TOWN AND COUNTRY PLANNING ACT 1990 NON MATERIAL AMENDMENT

Reference: H08-1031-25 **Date of Decision:** 31st October 2025
Applicant: R K Wilson Builders Ltd.
C/O Robert Doughty Consultancy Limited
32 High Street
Helpringham
Sleaford
NG34 0RA
Location: Riseholme Farm Windmill Lane Gosberton Risegate Spalding
Description: Erection of 6 single storey dwellings and garages, formation of parking and bin collection point and reinstatement of existing access - approved under H08-0282-24. Amendments to foundation design to that required under Condition 3 of approval H08-0282-24

South Holland District Council hereby give notice that this application has been REFUSED in respect of the non-material amendments referred to above for the following reason(s):

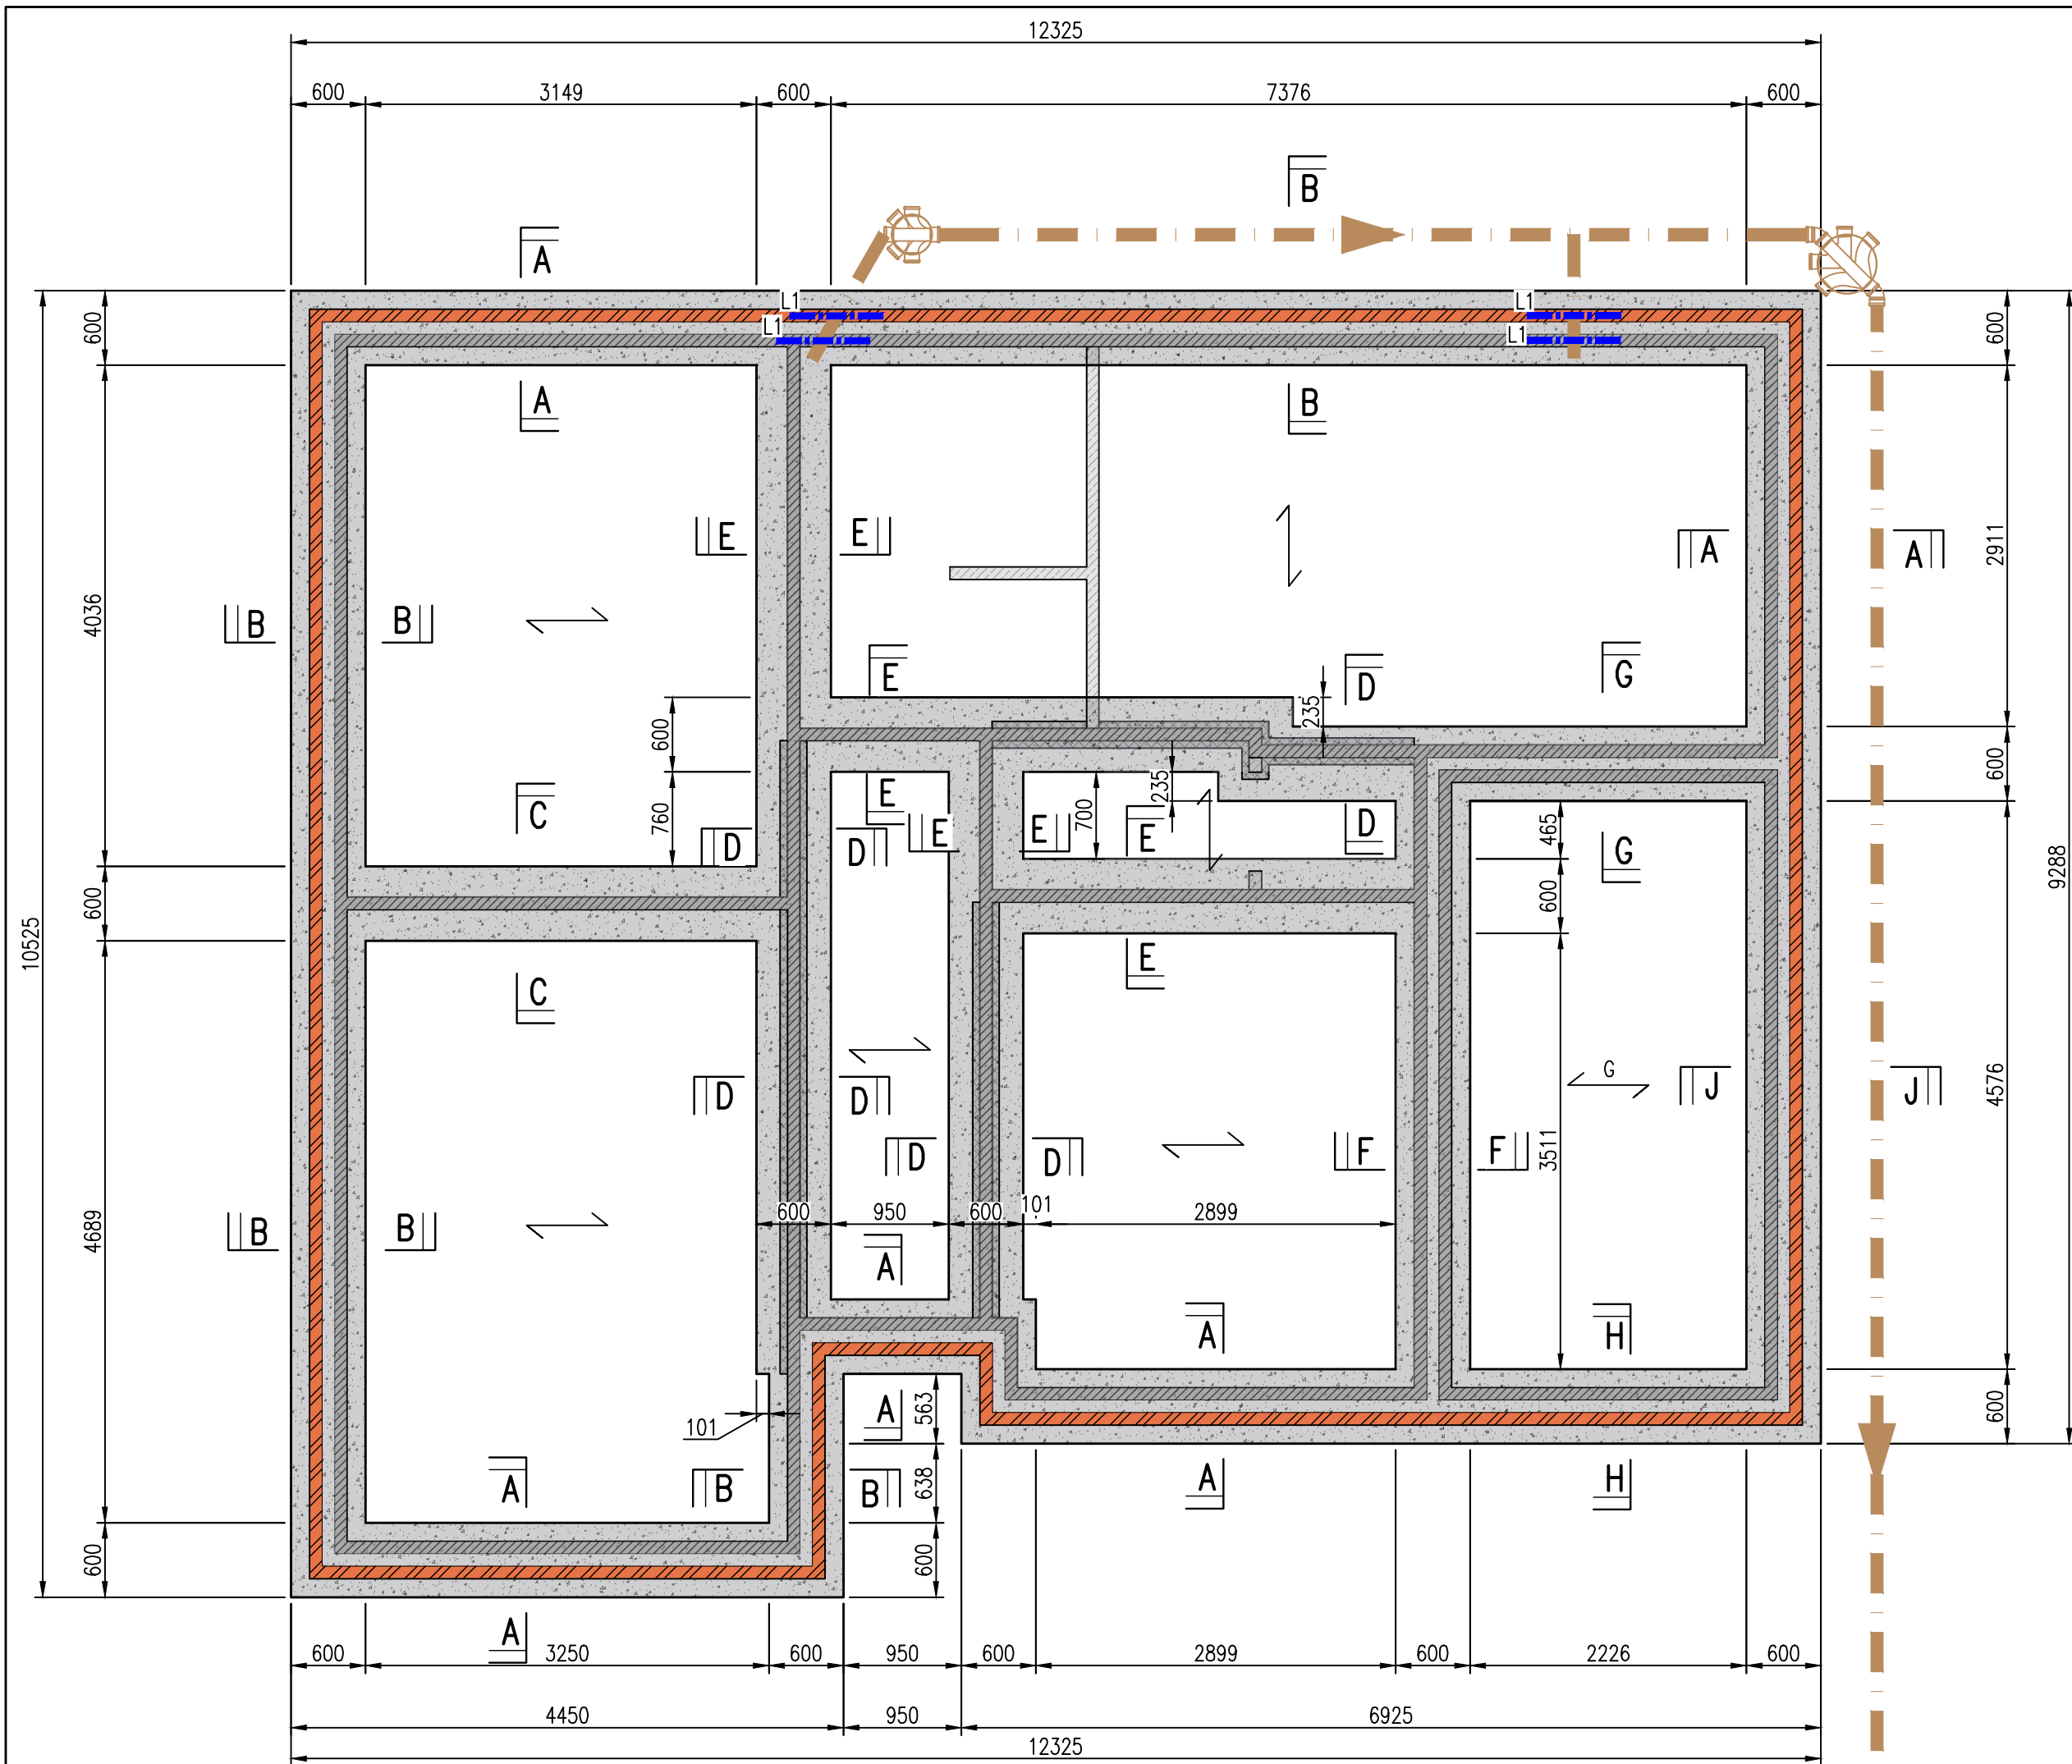
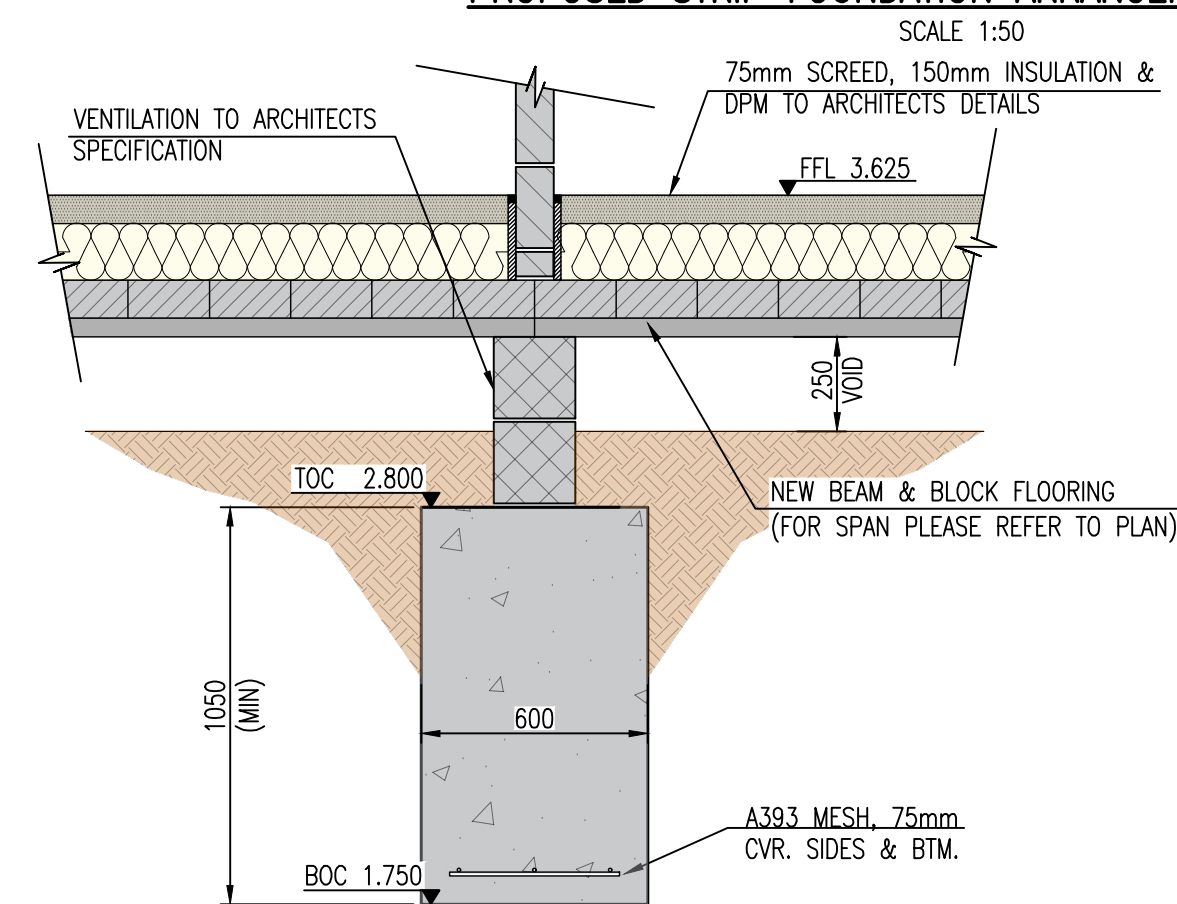
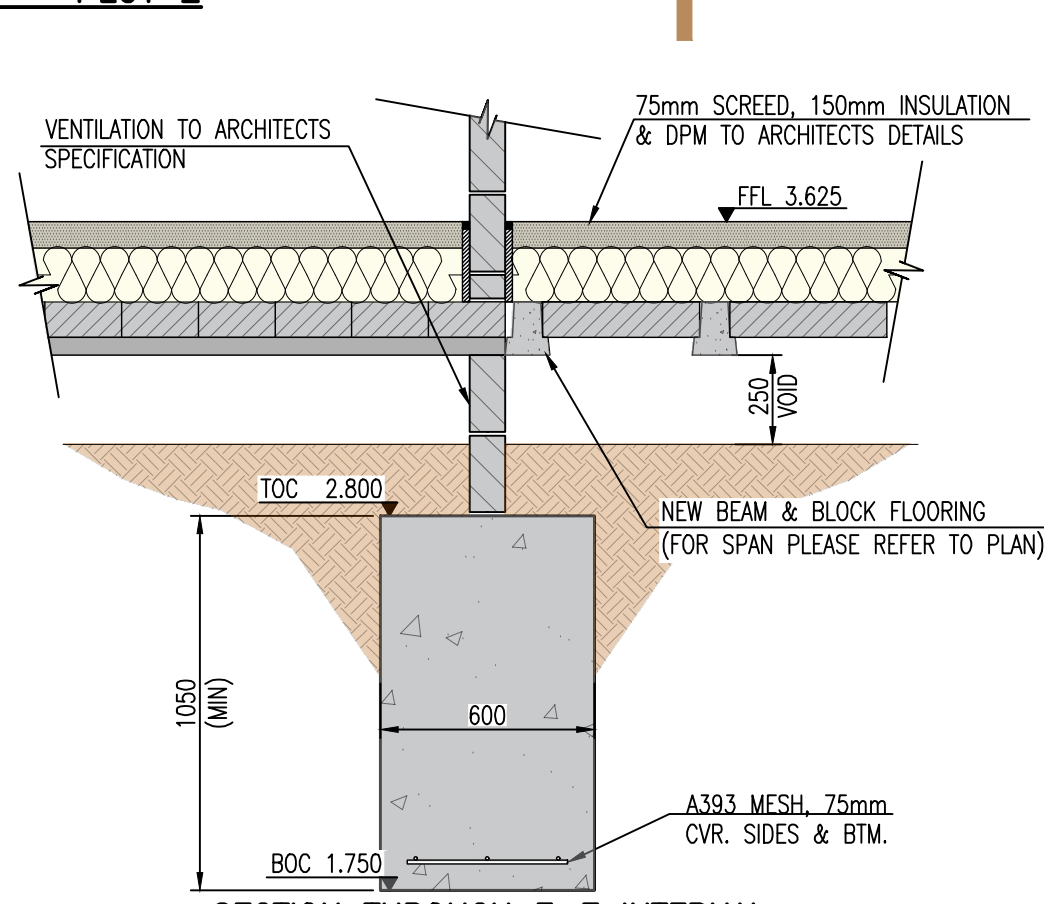
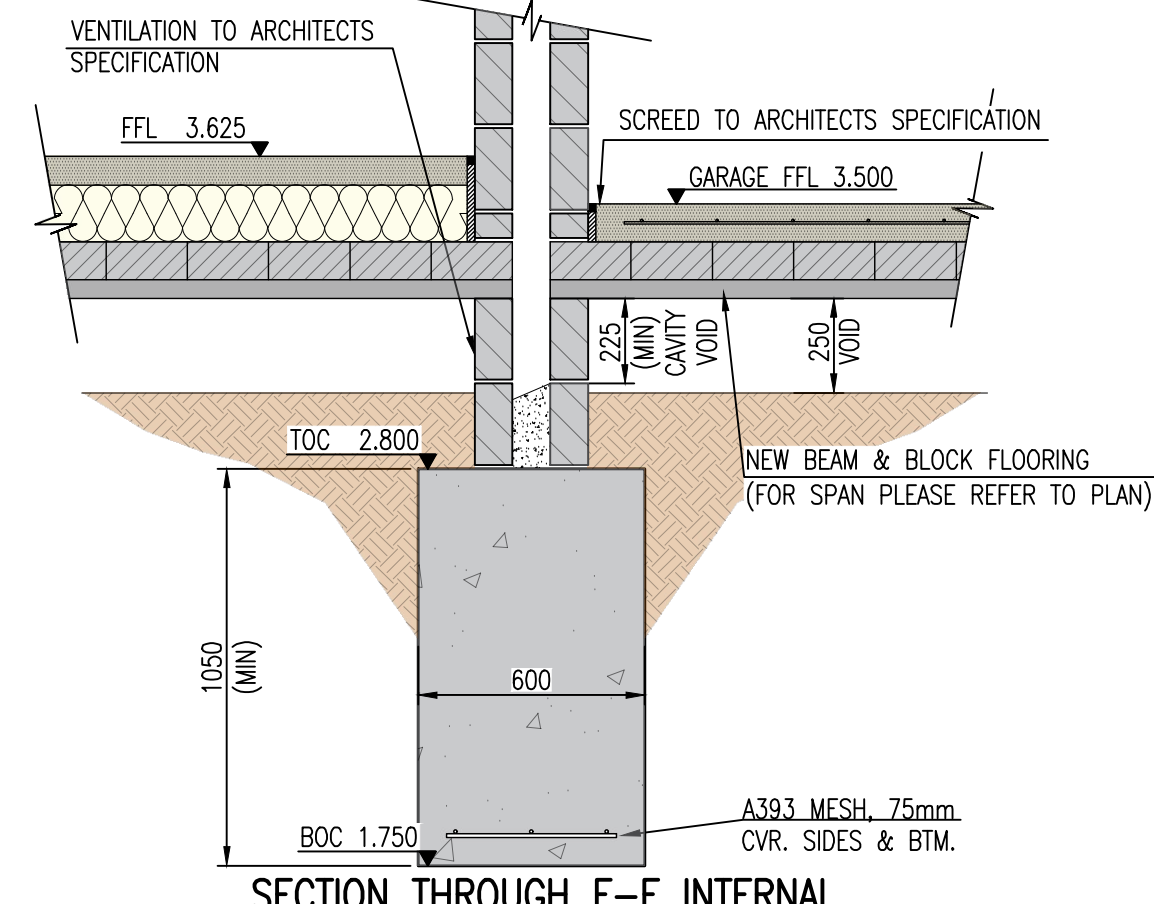
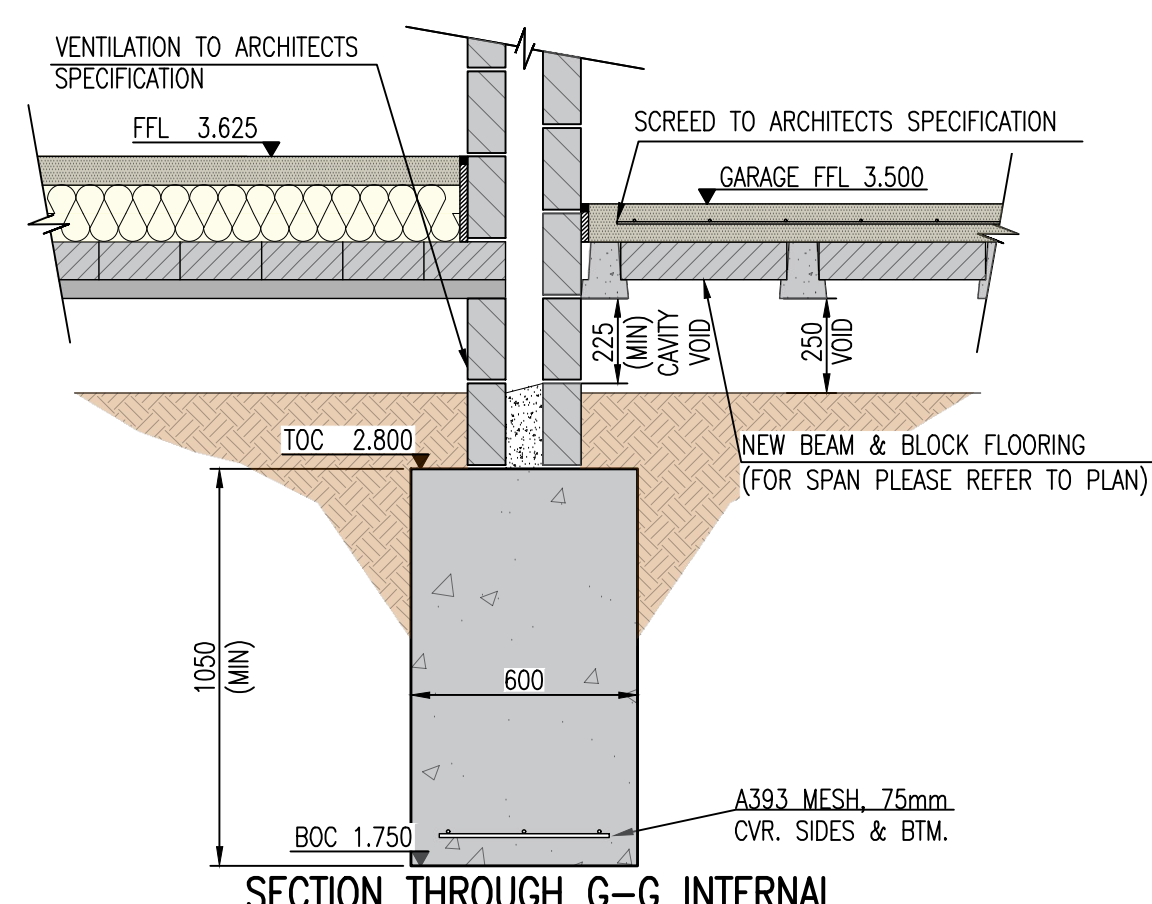
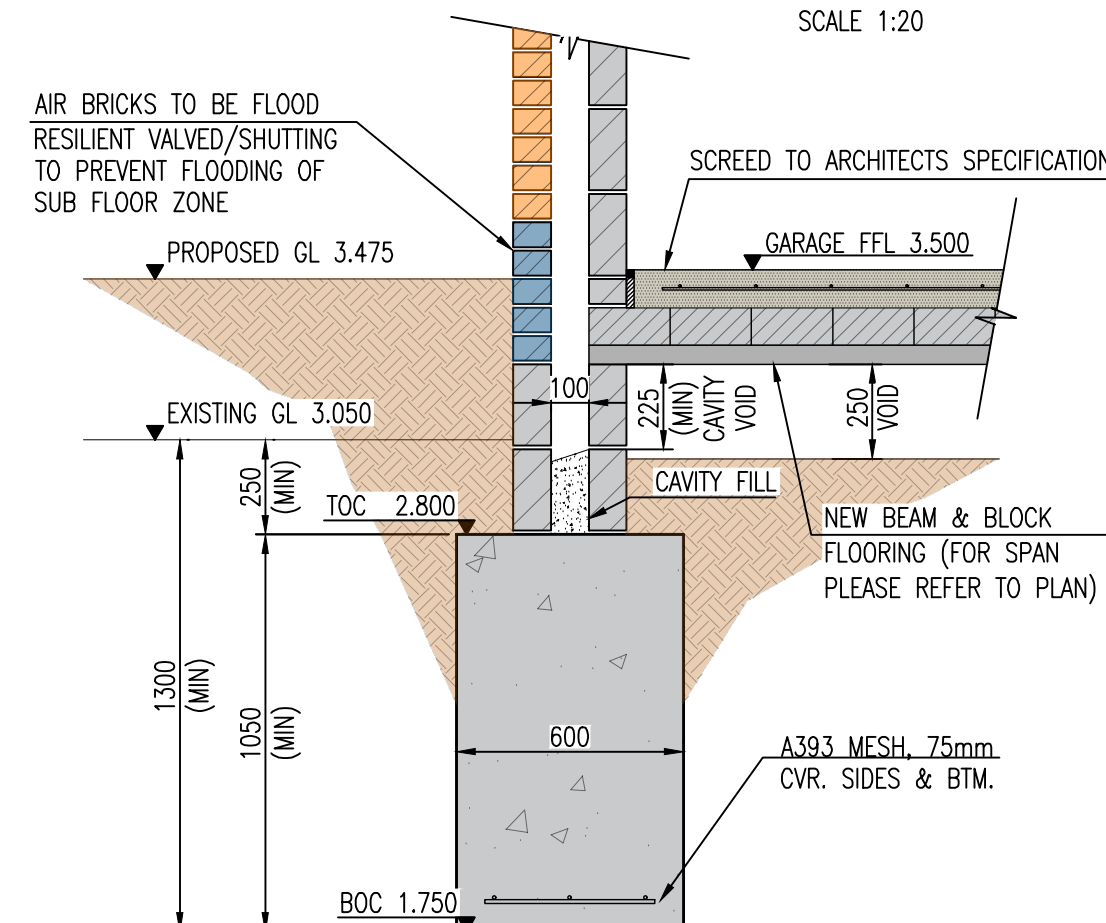
- 1 Point 8 of South Holland District Council's guidance on non-material amendments confirms that such amendments must not result in a fundamental change to the design of the approved building. The approved Flood Risk Assessment (FRA) by RM Associates establishes a critical flood resilience requirement that "the ground floor shall be constructed with a solid concrete floor with no voids beneath and no low-level wall vents." The proposed introduction of a strip foundation incorporating voids beneath the floor would fundamentally alter this key element of the approved design and directly conflict with the flood mitigation measures integral to the scheme's acceptability.

Accordingly, the amendment would constitute a material change to the approved development and cannot be treated as a non-material amendment under Section 96A of the Town and Country Planning Act 1990 (as amended).
